BY: _____
 SHEET TITLE: **SITE PLAN**

ADDRESS: **1365 Murphy Rd.
 Elbert, CO 80106**

SHEET: **S-1**

S-1

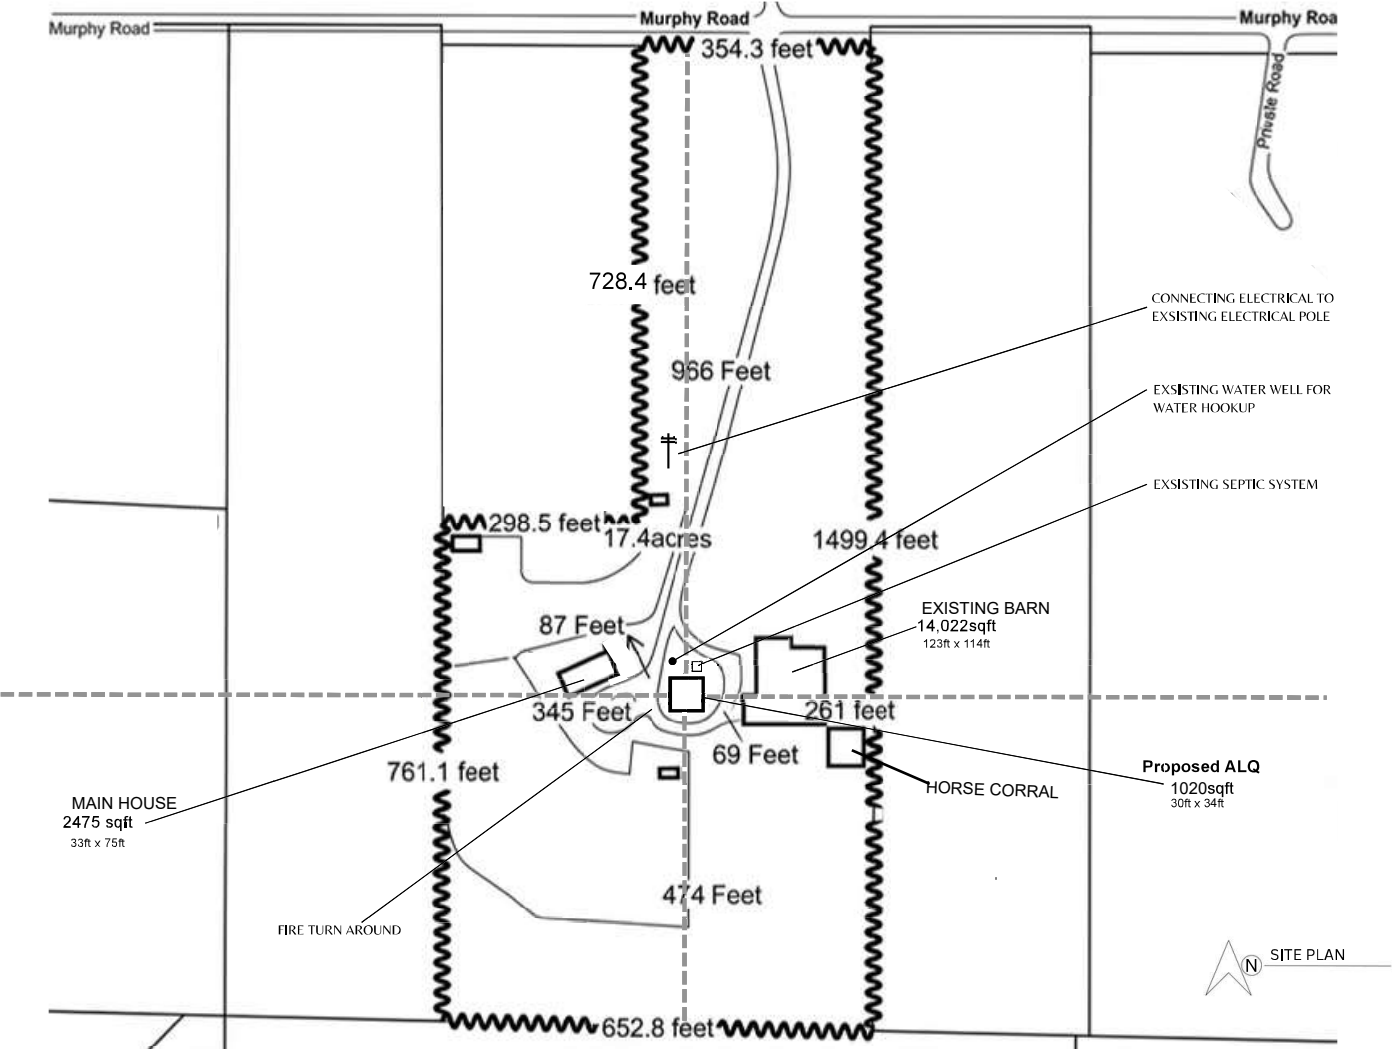
Please label and add the square footage of all structures including the primary home, accessory structures etc.

Please label as "Proposed ALQ"

Please review Falcon Fire comments regarding depicting truck turn around.

Please add the following: north arrow, parcel #4205003008, RR-5 zoning, ownership info, and legal description.

Please add: PCD File No. AL2615
